Our Ref: 689/013
Your Ref: 18/01333/F
Date: 11th October 2019

VARIATION OF CONDITIONS FOR PLANNING PERMISSION 18/01333/F

We write to submit information for the variation of conditions attached to planning permission 18/01333/F. The application was for the extension to existing Technical Site to provide new employment units comprising flexible B1(c) light industrial, B2 (general industrial), B8 (storage or distribution) uses with ancillary offices, storage, display and sales, together with associated access, parking and landscaping. The application to vary the conditions has been made via the planning portal under reference PP-08147840.

TITLE:
Building B Proposed Elevations

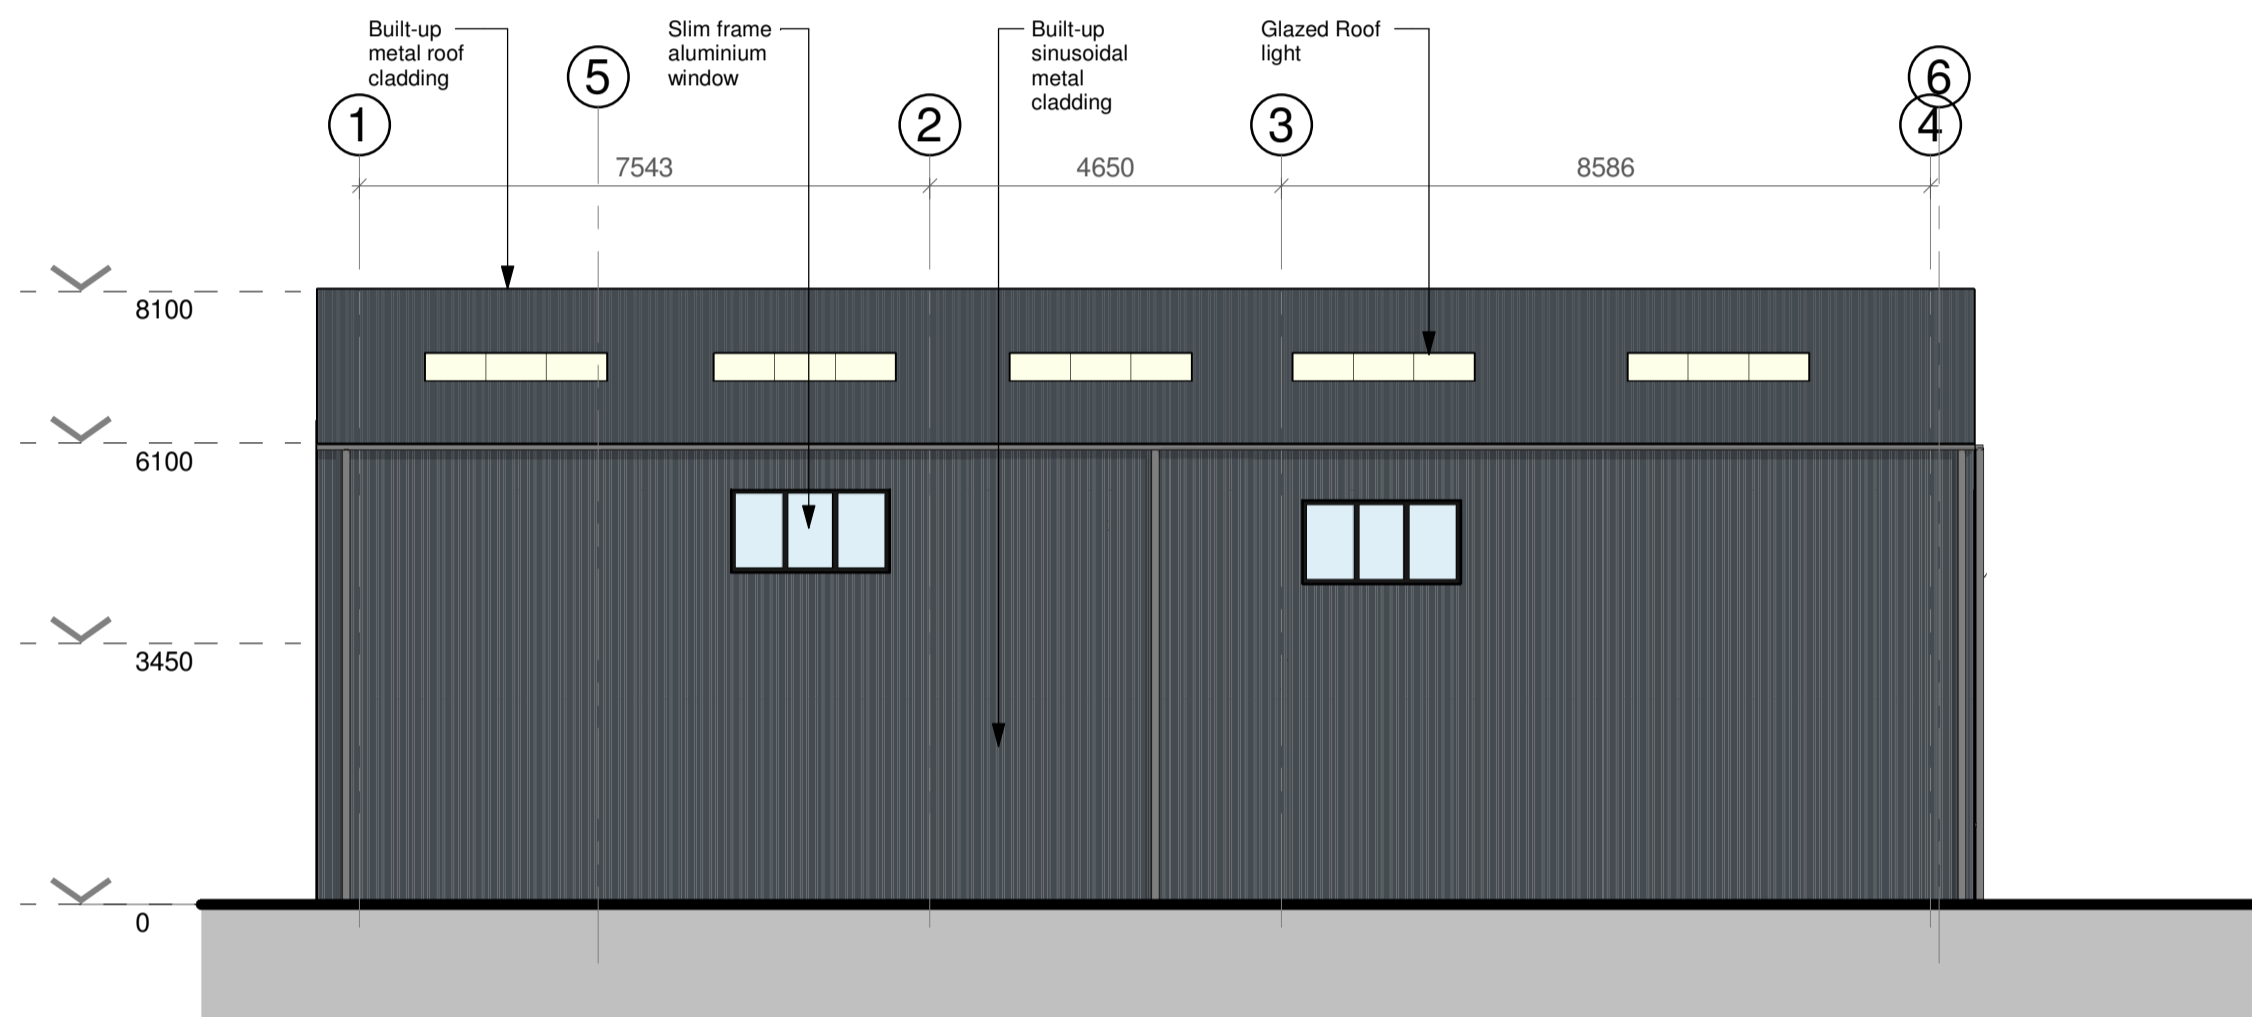
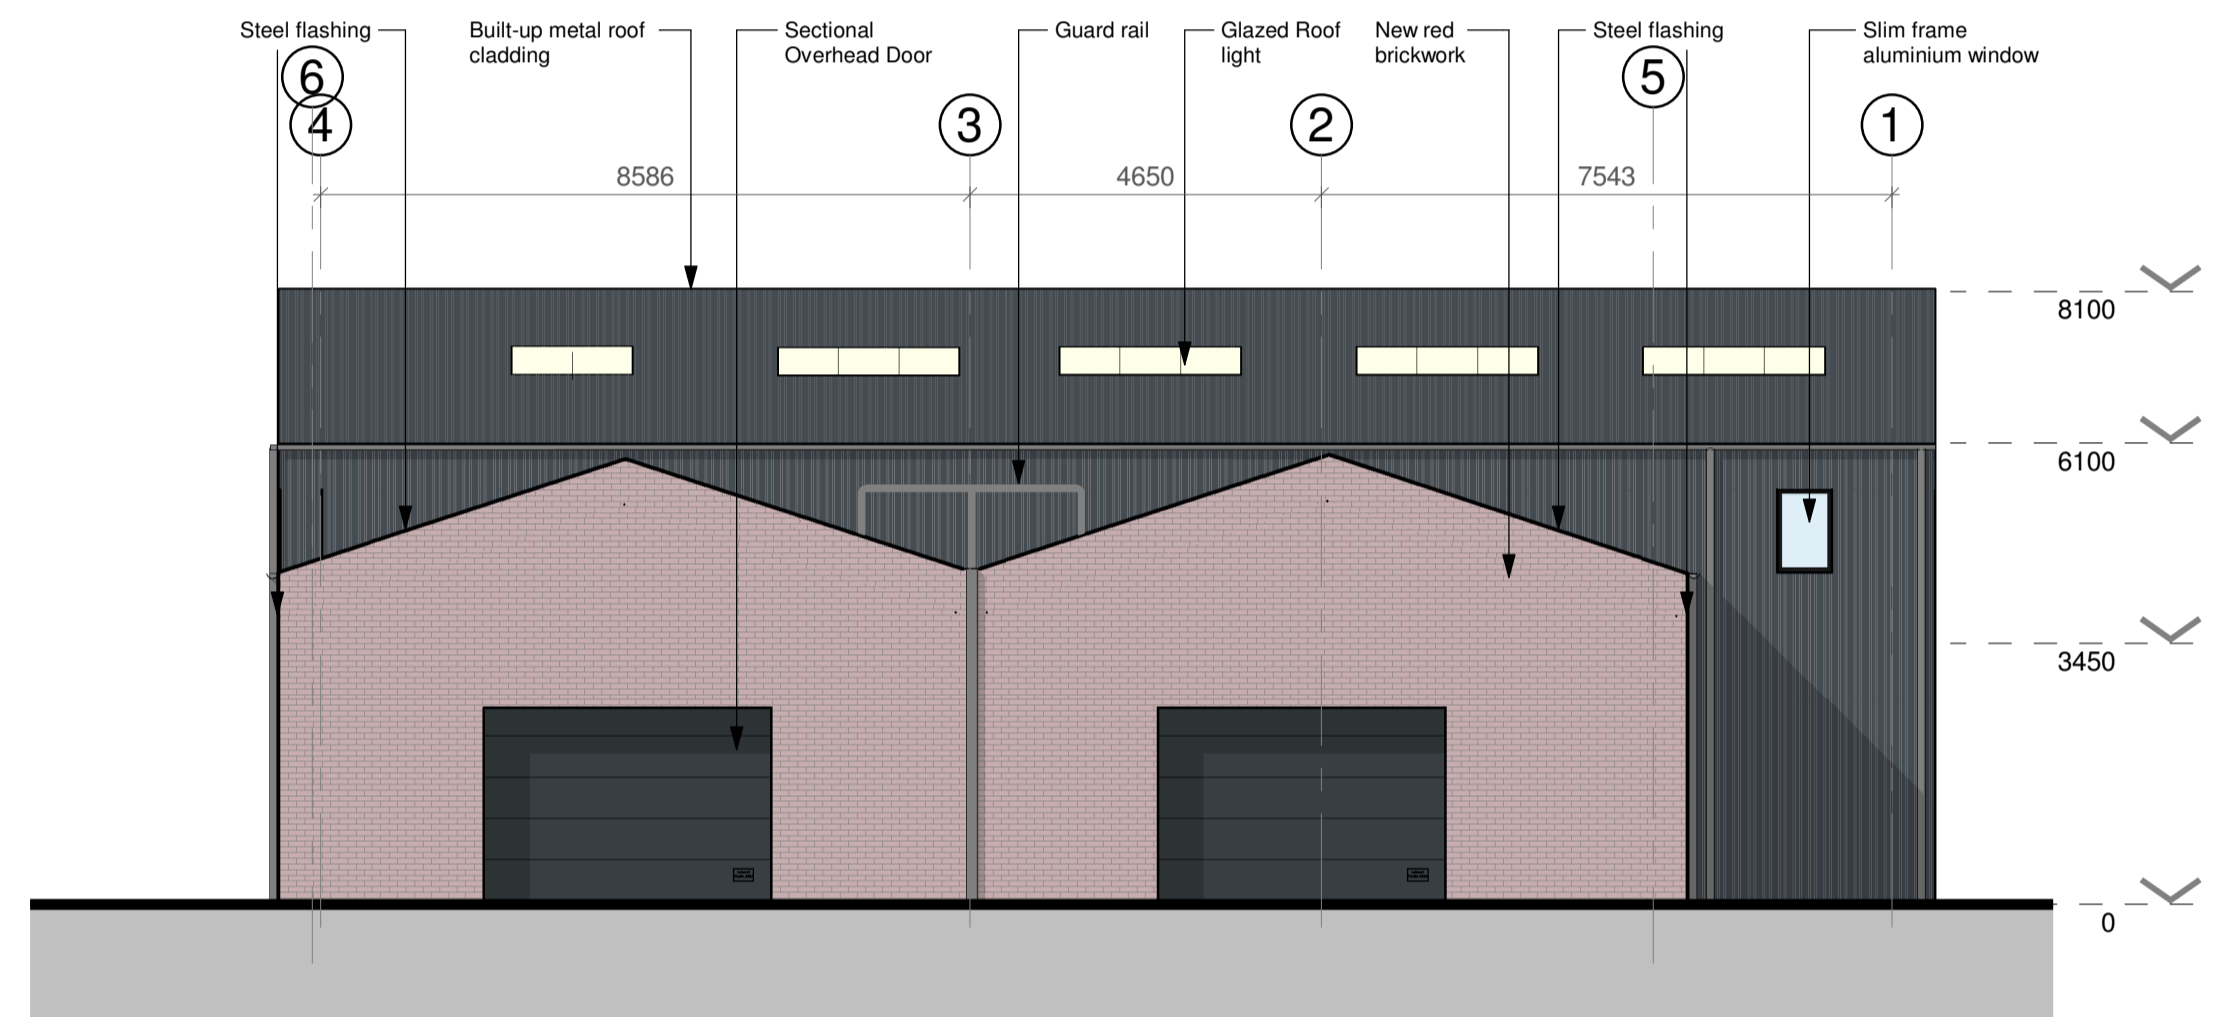
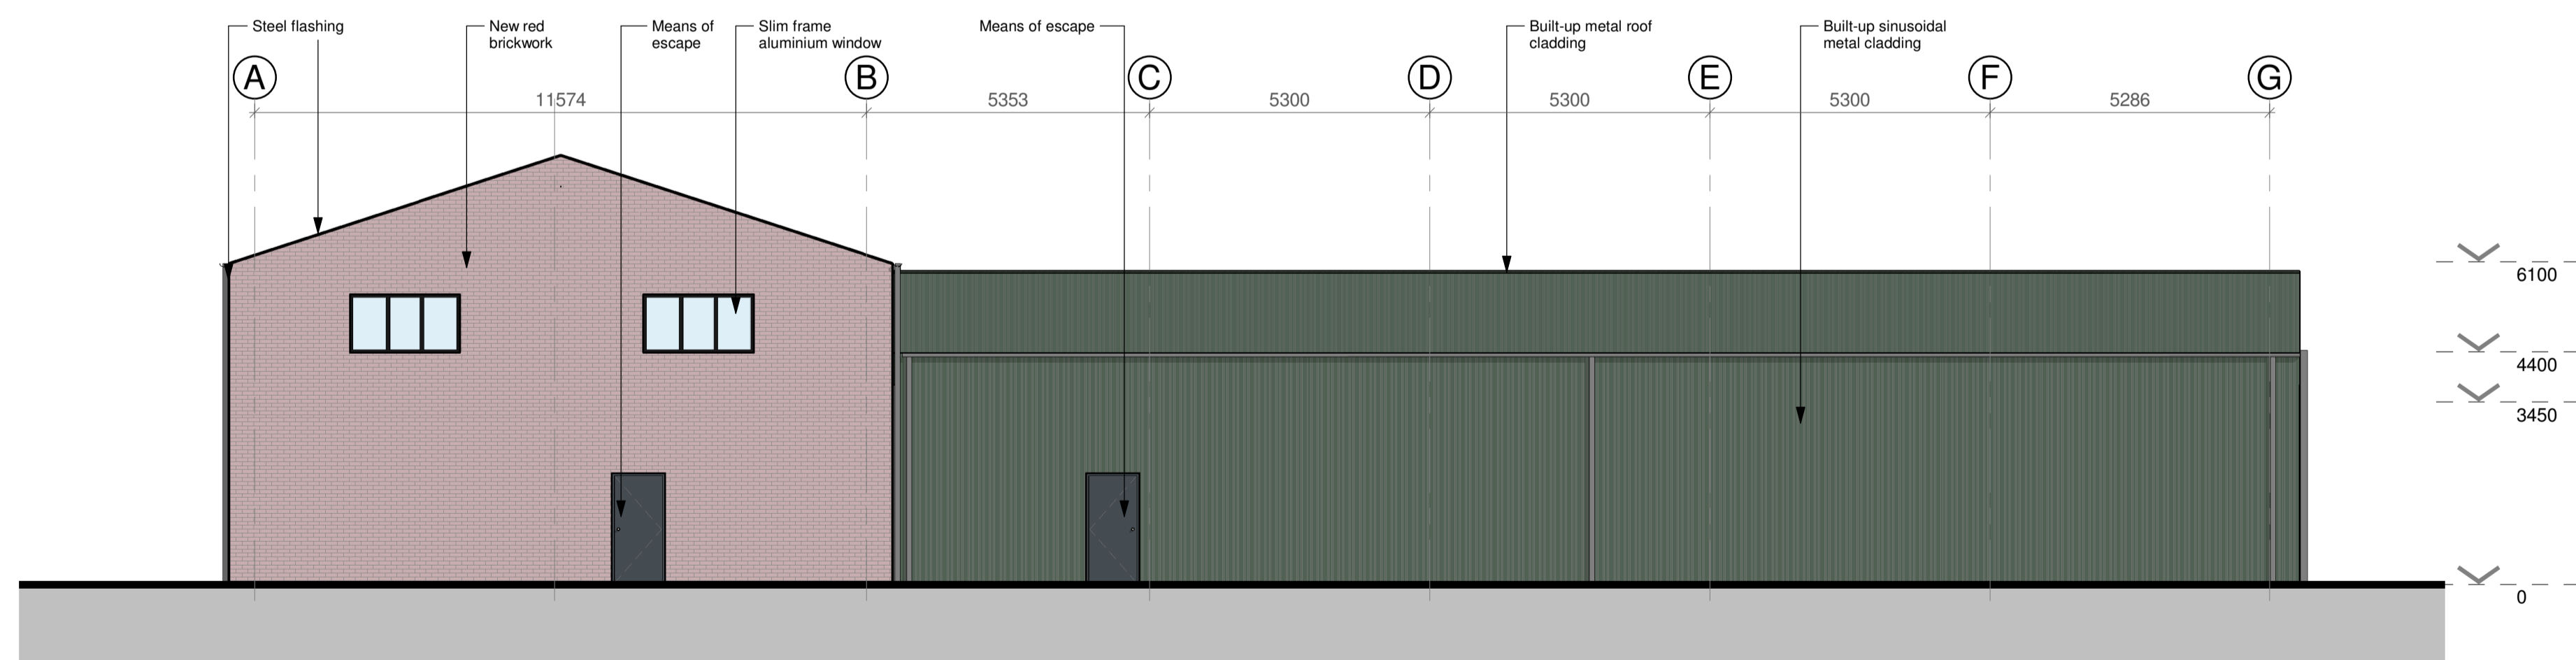
Drawing / Unit		Changes
		Locations of car parking bays
		A new staircase for Unit C added
		Future charging points introduced
		Infiltration basin shape changed
		Surface Treatment amendments around buildings
Unit A	GF	A sectional overhead door replaced with fully openable glass panel
		Two high level windows added
Unit B	GF	A glass panel with access door replaced with fully openable glass panel
		A sectional overhead door replaced with a glass panel with access door
		A sectional overhead door removed
		A glass panel with access door replaced with a sectional overhead door with wicket door
		An escape door added
		An escape door relocated
		Staircase relocated
	FF	A window relocated
		A window size increased, and window relocated
	Roof	Four rooflight added
		One rooflight relocated
		One rooflight size decreased
	Unit C	GF
External staircase and balustrade added		
FF		Two windows added
		One access door to terrace added
